Environmental Health Consultation Response	Officer	Michaela Gleave
--	---------	-----------------

Detail: Proposed erection of 9 new dwellings and associated works.

Address:	Land Behind The Dog Inn Market Place Longridge PR3 3RR			 Ribble Valley Borough Council www.ribblevalley.gov.uk
Application Ref:	03/2021/0275	Case Officer:	Adam Birkett	
Response Ref:	46081/Y01	Issue Date:	10 th May 2021

Figure 1 – Aerial Photograph

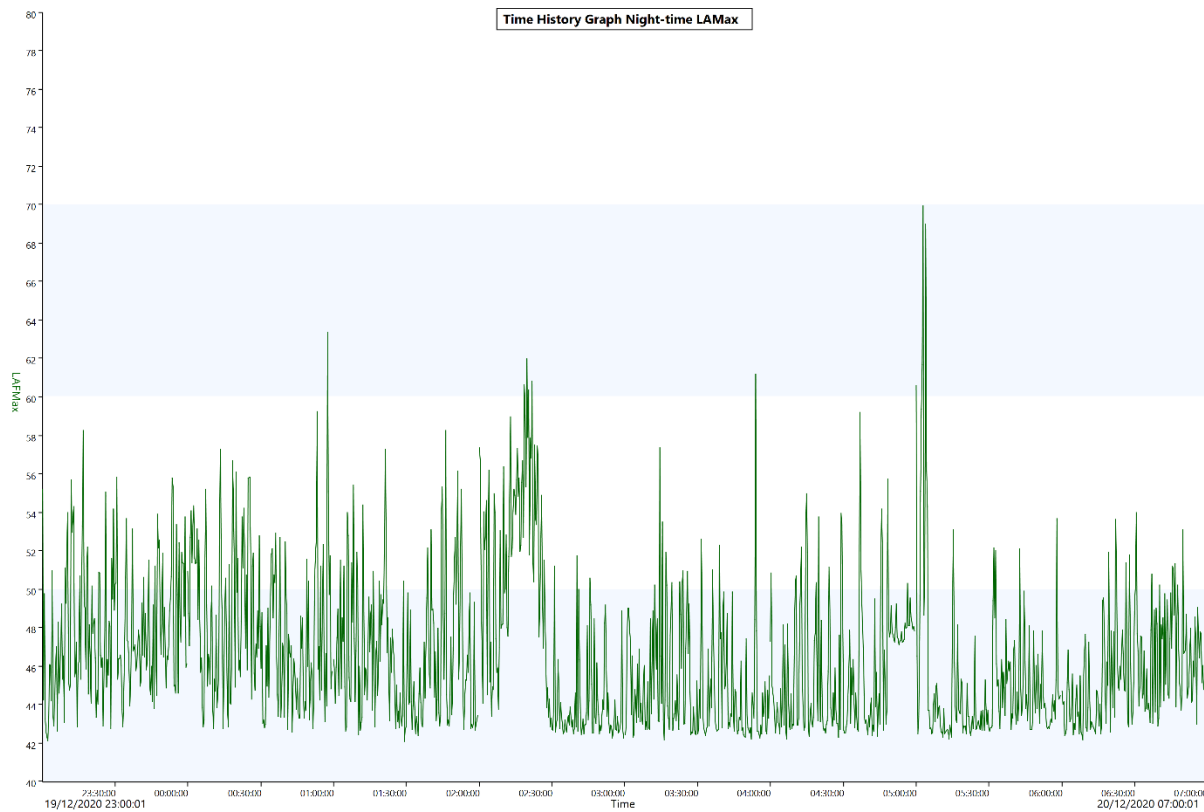
1.2	The noise assessment appears to only cover sound levels from internal sources (customers eating and drinking) from the public house with sound levels taken during the reduced usage of the public house due to pandemic restrictions; Environmental Health would therefore recommend that the noise assessment be extended to cover the aspects below.
Conclusions/Suggested Conditions	
NOISE

2.1	The noise assessment should be extended to include sound levels that would represent sound levels emanating from the normal usage of a public house that has indoor and outdoor customers and a licence for the performance of indoor/outdoor live and recorded music.

2.2	The noise assessment should include a description of any mitigating measures that may be needed, should a potential noise nuisance to the occupiers of the proposed residential development be identified from 2.1 above.

2.3	The noise assessment does not provide clarity on whether there will be any windows in the proposed housing development that will face onto the Dog Inn and, if so, what glazing specification is proposed. The noise assessment should provide a glazing specification for all windows to the proposed development, after taking account of noise levels recorded as per 2.1 above.
<div> <div></div> <div>Officer:</div> <div>Michaela Gleave</div> </div>
